TRAFFIC IMPACT STUDY

Schmidt Property
El Paso County, Colorado
PCD File No. P-22-022

September 2022
Revised:
January 2023

SM ROCHA, LLC
TRAFFIC AND TRANSPORTATION CONSULTANTS

Figure 2
CONCEPTUAL SITE PLAN
September 2022
Page 4

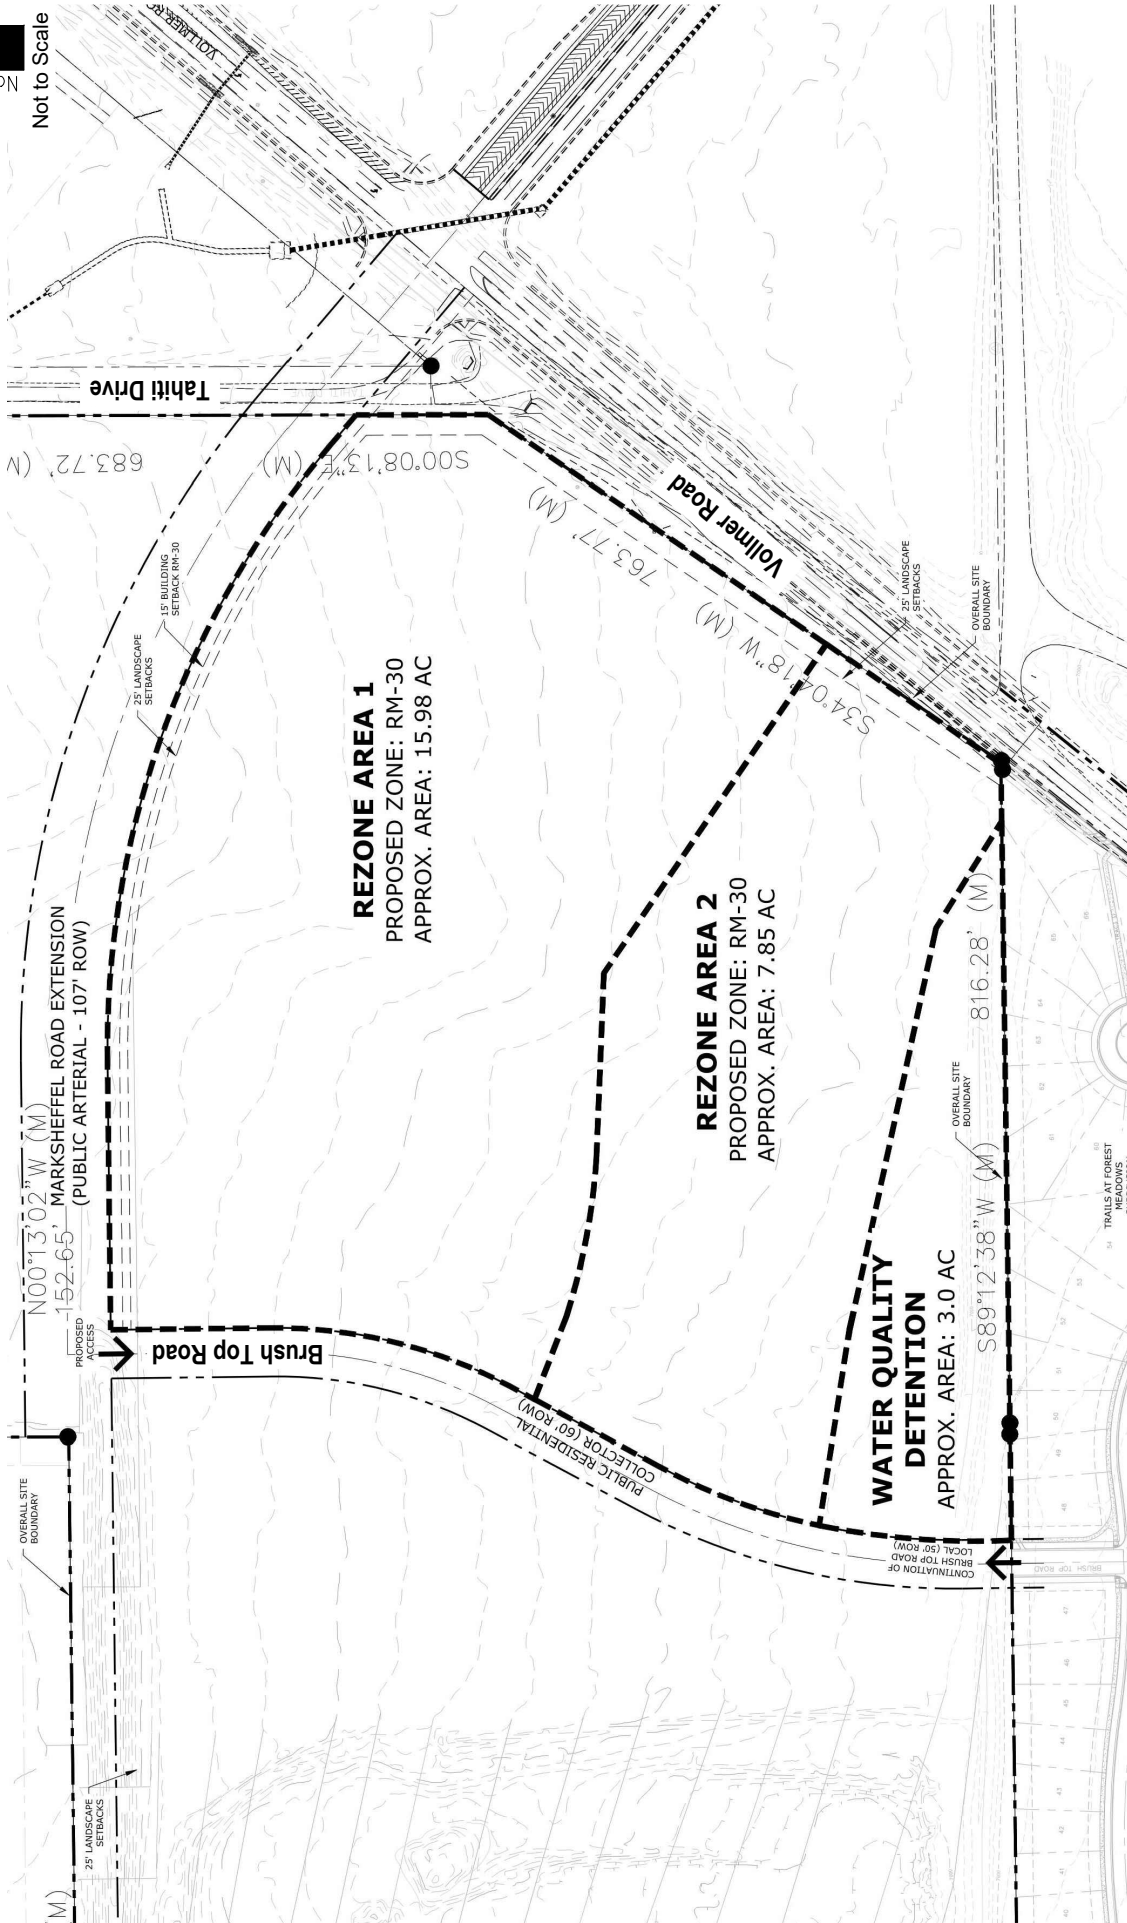
Based on intersection spacing requirements, full movement access at this location will not be approved. Any proposed deviations for limited access would need to be discussed prior to submittal.

Indicate if any ROW needs to be dedicated for Vollmer Road improvements

Figure 4
BACKGROUND TRAFFIC - YEAR 2027
 Volumes & Intersection Geometry
 AM / PM Peak Hour
 (ADT) : Average Daily Traffic

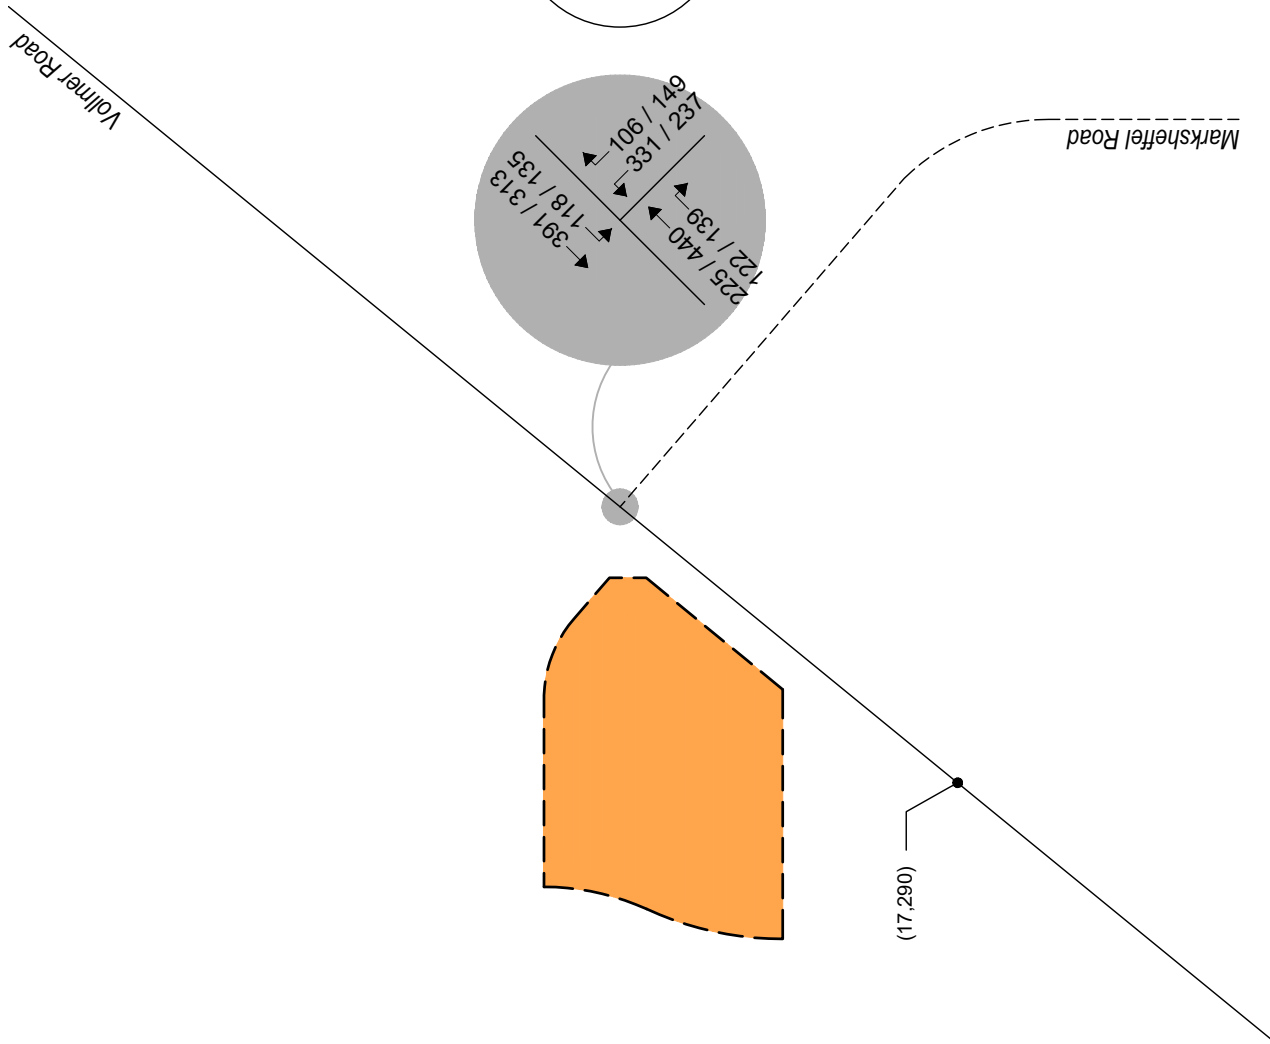
Include discussion on where Business Drive came from and what its configuration is, as it's shown under future conditions analysis - Background traffic
